WEST SUSSEX COUNTY COUNCIL STRATEGIC PLANNING CONSULTATION

SUBJECT: BN/32/15/OUT Outline application with all matters reserved for the erection of 38 No. dwellings including open space, landscaping & new access. This application is a Departure from the Development Plan.

Land Rear of the Lillies, Yapton Road, Barnham, PO22 0AY

(1) AUTOTRACK SWEEP PATH – LARGE 11m REFUSE VEHICLE ENTER AND EXIT SITE IN FORWARD GEAR

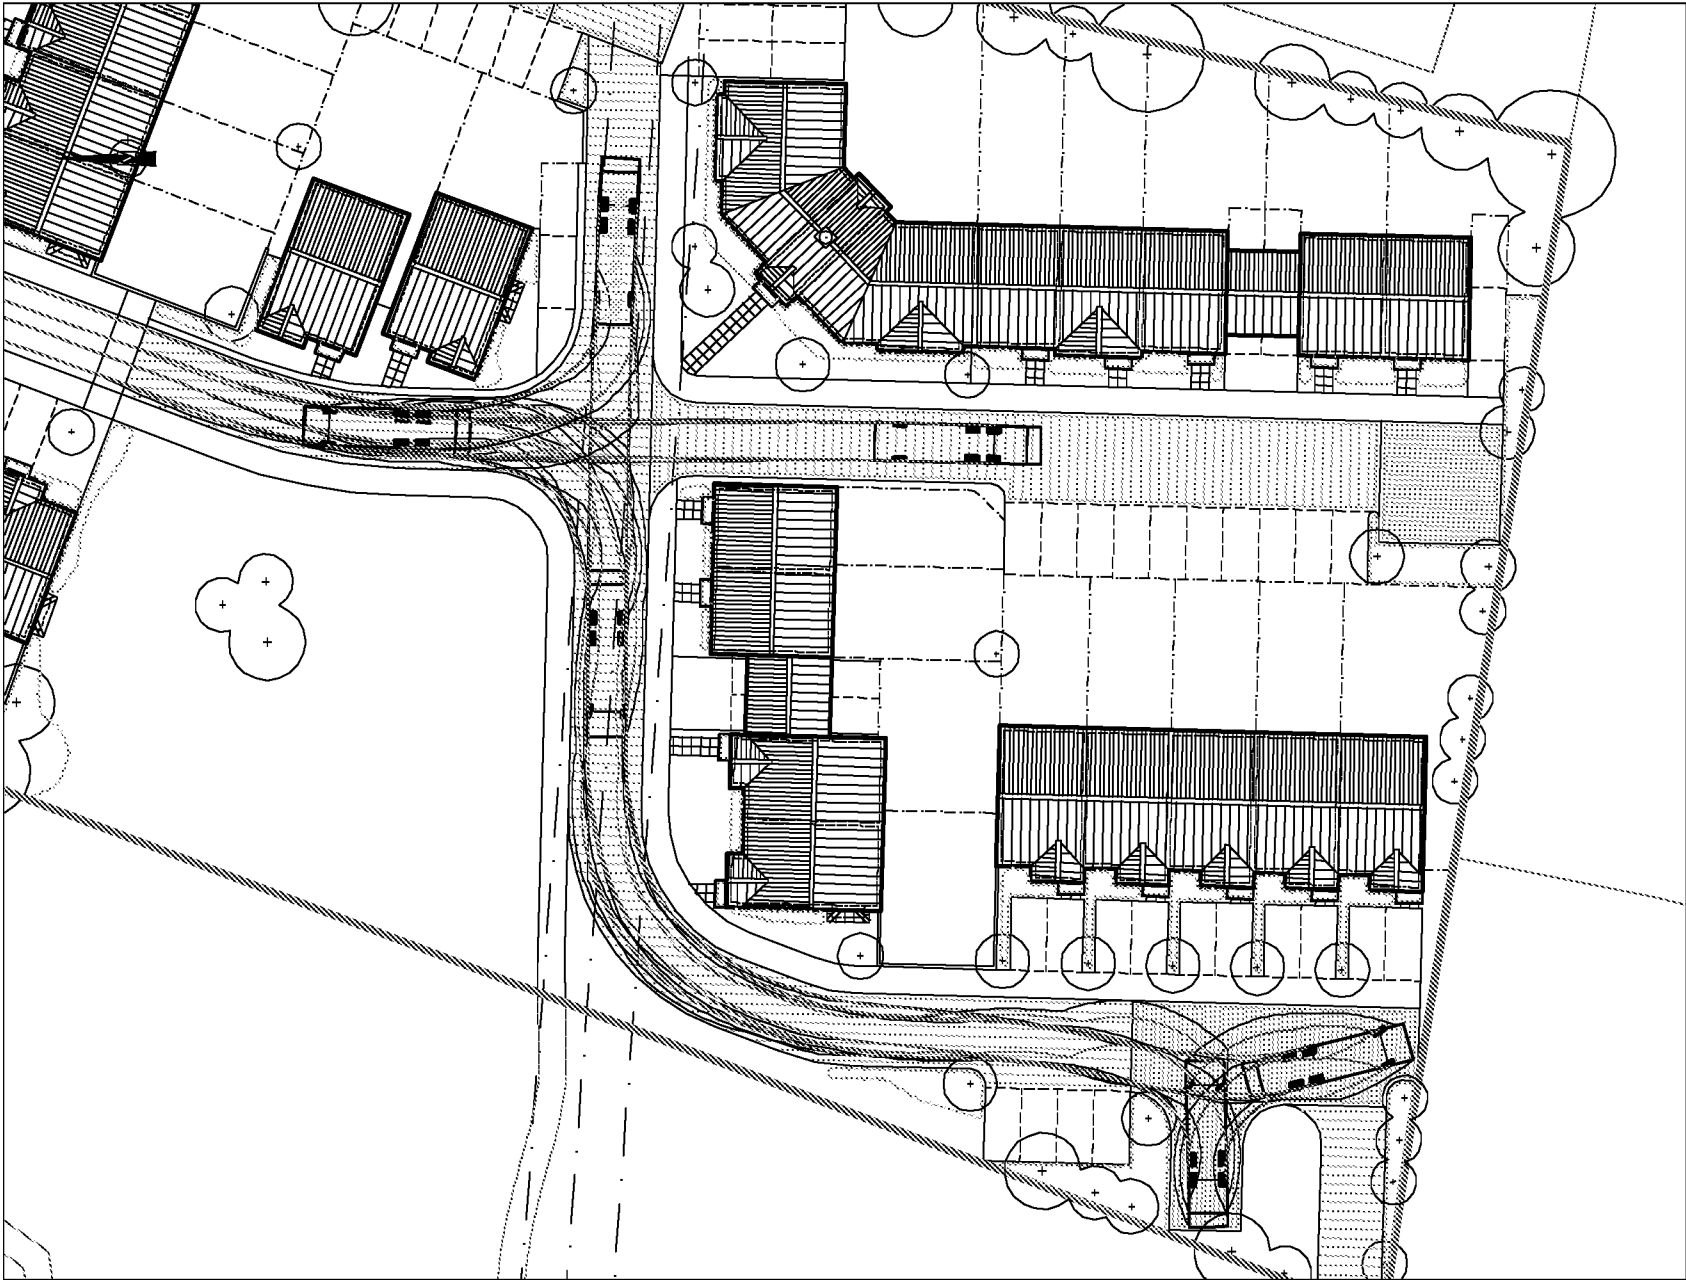
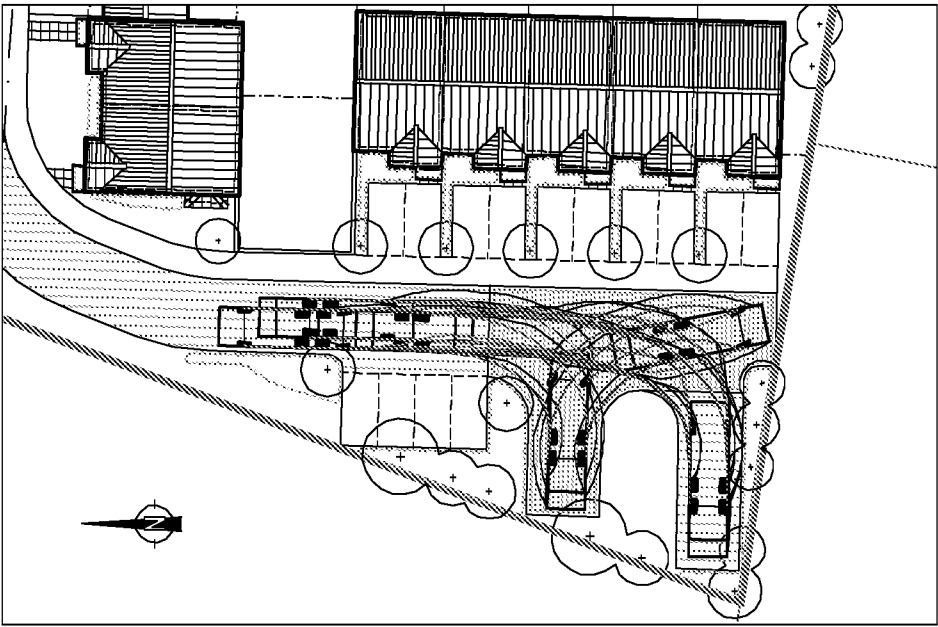
Refuse vehicle tracking has been provided in drawing number 5184.002. This will be further assessed at the Reserved Matters Stage along with the internal site layout, however the Applicant will need to demonstrate that a refuse vehicle can get to within 25m of the storage point and if bin collection points are required, residents should not be required to carry waste more than 30m to the storage point, in line with MfS requirements.
